Re: Revised Structural Observation — *101 North 12th Street, Erwin, NC 28339*

At your request, on October 29, 2025 we performed an on-site visual inspection and review of the structural plan proposed by *Tar Heel Basement Systems* for the first-floor framing reinforcement work at the Erwin residence noted above. The structure is a conventionally framed, detached, single family residence with raised first floor framing over a pier/curtain wall foundation system (see *picture 1*). Our observations are listed below. Indicators such as "left," "right," "front," and "back" are

R1 referenced as viewing the front of the home. This report has been revised to include a repair schematic which was initially omitted.

Foundation Plan

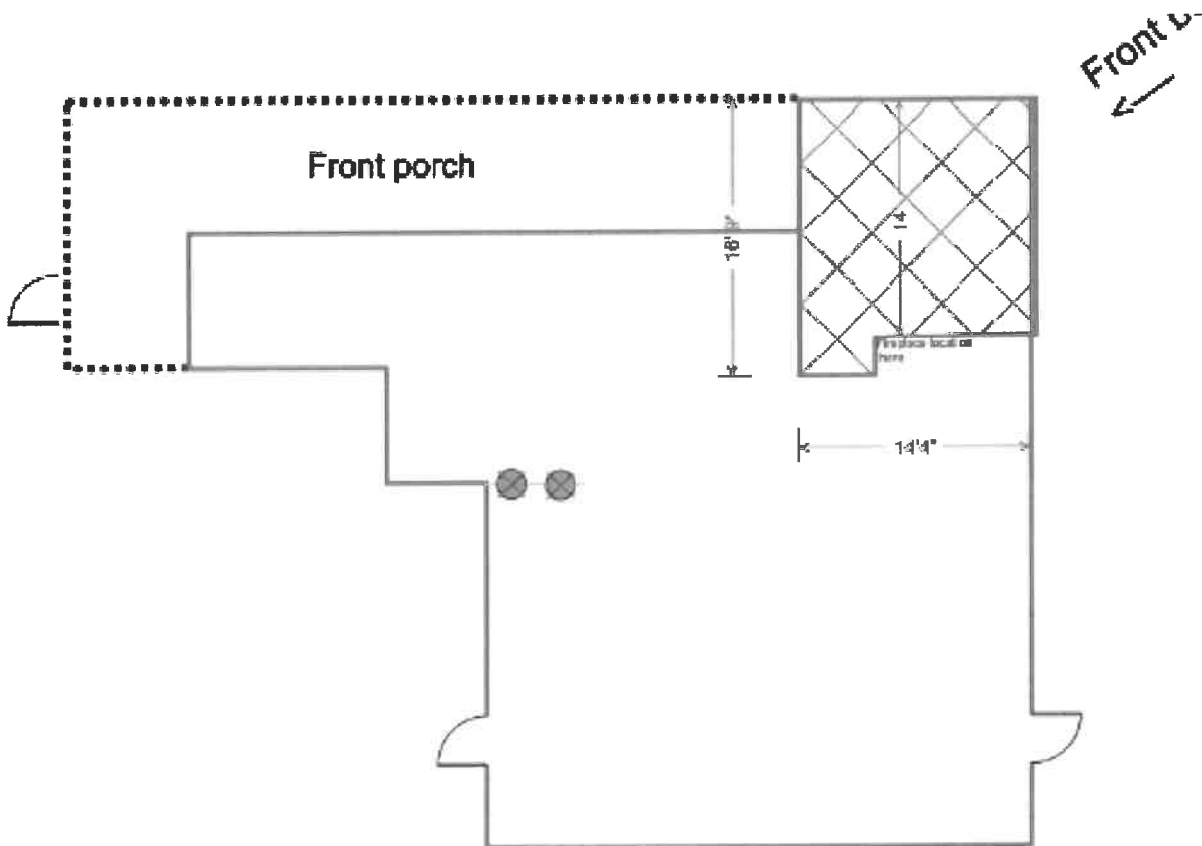
- Numerous brick support piers were noted to be in poor condition and providing inadequate support (see *repair plan for approximate locations* and *pictures 2-3 for examples*).

- A significant portion of the crawlspace was unable to be accessed during our site visit due to space constraints (see *picture 4 and the attached repair plan for additional information*).

- The crawlspace was noted to be excessively wet during our site visit. No vapor barrier was observed.
- The front-right joist span was noted to be visibly sagging.

- Limited investigation from the crawlspace revealed the 5th-7th joists from the right were deteriorated (see *pictures 5-6 for examples*).
 - Measurement by laser level indicated the floor joists were sagging by as much as approximately 1 $\frac{3}{8}$ " at midspan.

- Significant slopes in the floor were noted near the back bathroom as well as the left side of the home (see *picture 7 for example*).
 - As noted above, the framing beneath these areas was inaccessible at the time of our site visit; however, significant deterioration was visually apparent (see *picture 8*).

- 1) Remove and replace all improper brick pier supports with new CMU piers constructed per the attached detail (see *Detail 1*) and centered over a 24"x24"x10" thick poured concrete footings.

- a) The middle brick support pier located approximately 16' from the back of the home, and 8' from the left of the home, may be replaced with an IntelliJack support founded atop a well-compacted 18"x18"x18" gravel footing (see *Detail 2*).

- 2) Reinforce the back most girder bay at midspan using an IntelliJack support on a well-compacted 18"x18"x18" gravel footing (see *Detail 2*).
- 3) Reinforce each of the deteriorated joists noted above with an additional ply of full-depth (2x8 minimum) 2x #2 Southern Yellow Pine (SYP), fastened to the side of the deteriorated joists using (3)10d common nails at each end and at 12" on-center staggered top and bottom along the lengths of the joists. Sistered material should span continuously between end supports.

- 4) To raise/stiffen the floors in the front-right of the home, install a supplemental S4x7.7 dropped girder within the middle 1/3 of the joists. The new girder should span the length of the joist bay and be supported over IntelliJack supports on well-compacted 18"x18"x18" gravel footings spaced no more than 6'-6" apart (see *Detail 2*).

- 5) Modern building standards require at least 18" of clearance from top of crawlspace soils to the undersides of joists, and at least 12" of clearance from top of crawlspace soils to the undersides of girders. We recommend removal of soils from the crawlspace as is necessary to achieve minimum clearances to help prevent significant deterioration of wood framing members due to rot. Care should be taken not to undermine foundation elements by removal of soils from the crawlspace.

- a) If excavation is not to be performed, any new framing material should be treated #2 SYP in areas where minimum clearances are not met.
- 6) We strongly advise additional investigation be performed including the select removal of finishes in the portions of the home that are significantly uneven.

- a) *Additional structural repairs, up-to and potentially including, re-framing may be required. The removal of finishes to expose the existing framing configuration and the extents of deterioration are required in order to facilitate design of the appropriate repairs.*

- 7) Due to the infeasibility of achieving adequate cross-ventilation of the crawlspace, we recommend installation of a Code-approved closed crawlspace system with adequate vapor liner and mechanical drying measures to help avoid future advanced framing deterioration due to wood rot.
